Planning Consultation Request

Application No.	2021/93270
Proposed Development:	Discharge of conditions 3 (construction management), 4 (temporary drainage), 5 (temporary waste arrangements), 7 (adoptable roads), 12 (waste storage and collection), 13 (tree protection), 14 (units 23 and 24 revisions), 16 (detailed drainage scheme), 17 (phase II report), 18 (remediation strategy), 23 (materials) and 31 (vegetation removal) of previous permission 2019/91657 for erection of 30 dwellings
Location:	Land at, Station Road, Skelmanthorpe, Huddersfield, HD8 9BA
OS Map Reference	SE 423238.1666 411120.2104
Applicant/Agent:	Yorkshire Country Properties
Class:	No Required

**Consultation Response from KC,
Lead Local Flood Authority**
2021/93270 Land at, Station Road, Skelmanthorpe, Huddersfield, HD8 9BA
Discharge of conditions 3 (construction management), 4 (temporary drainage), 5 (temporary waste arrangements), 7 (adoptable roads), 12 (waste storage and collection), 13 (tree protection), 14 (units 23 and 24 revisions), 16 (detailed drainage scheme), 17 (phase II report), 18 (remediation strategy), 23 (materials) and 31 (vegetation removal) of previous permission 2019/91657 for erection of 30 dwe

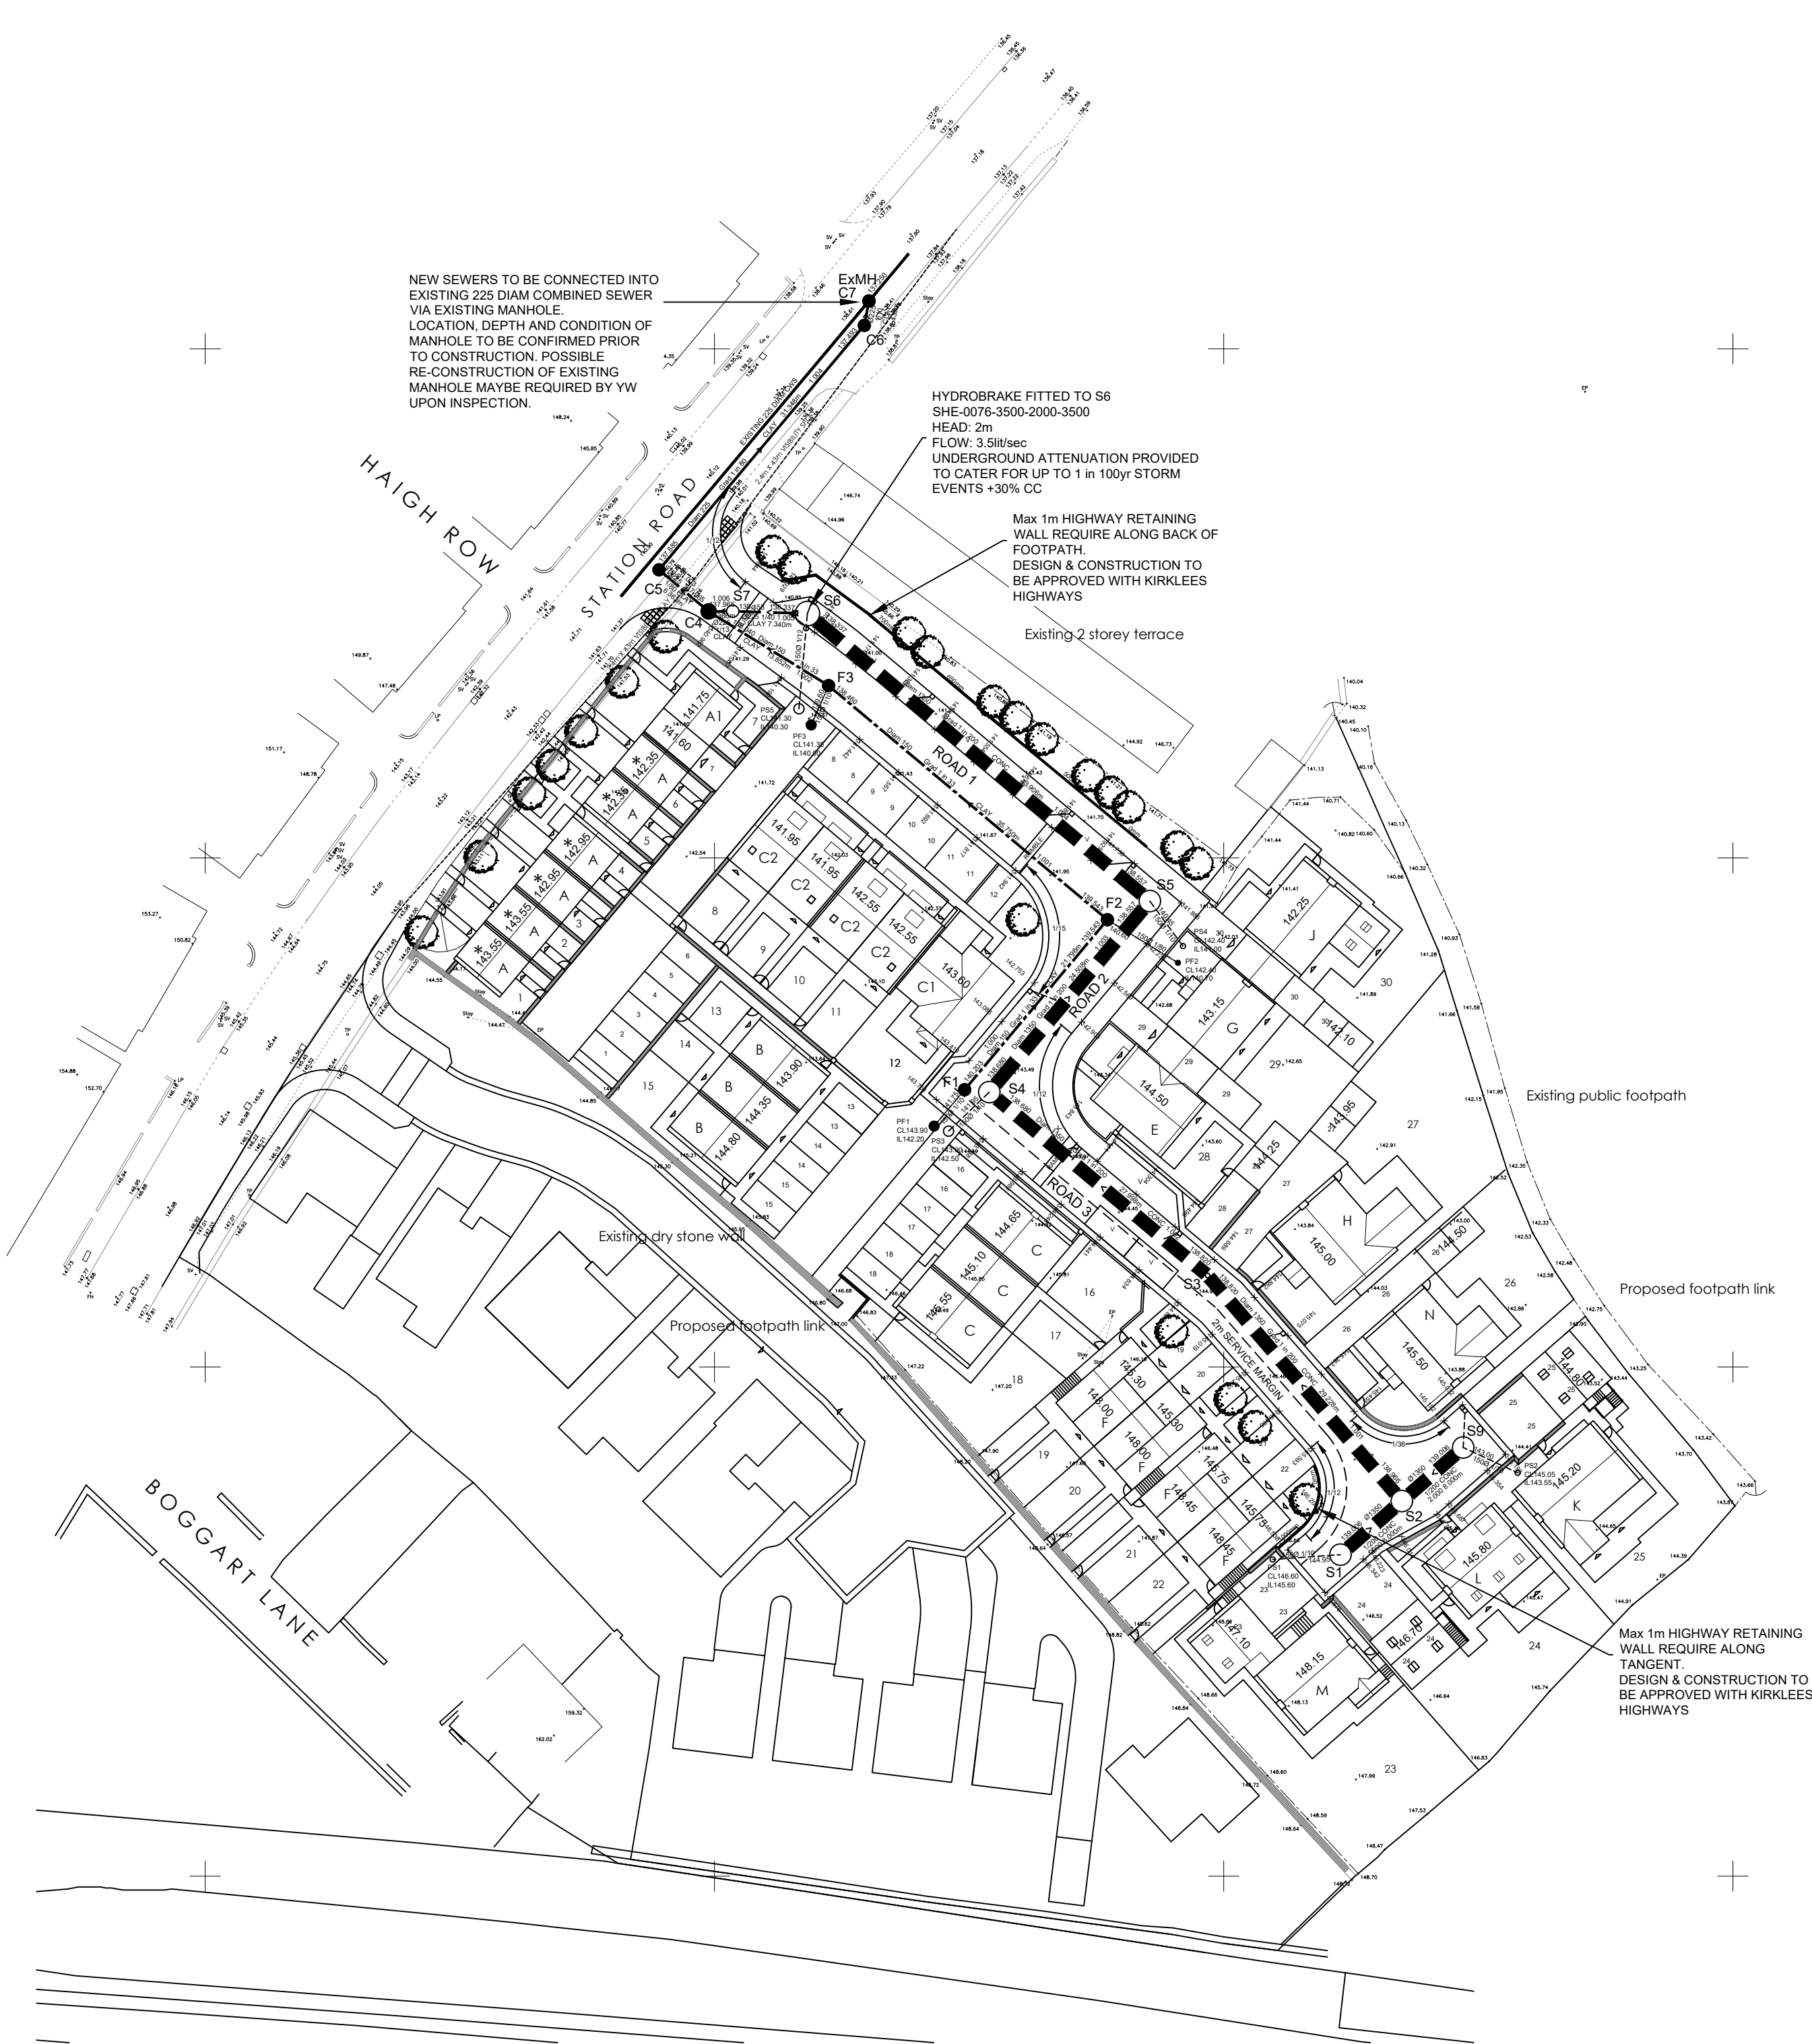
The LLFA accepts the drainage design. With regard to flood routing, further detailed information is required around the parking bay adjacent to plot 28 to ensure the low spot in this area is demonstrated by level including back of kerbs and to show that water if collecting at this point will weir over on the roadside and not into curtilage.

Similar evidence needs to be provided for the road narrowing around manhole S6

Further information is required BEFORE this condition can be discharged.
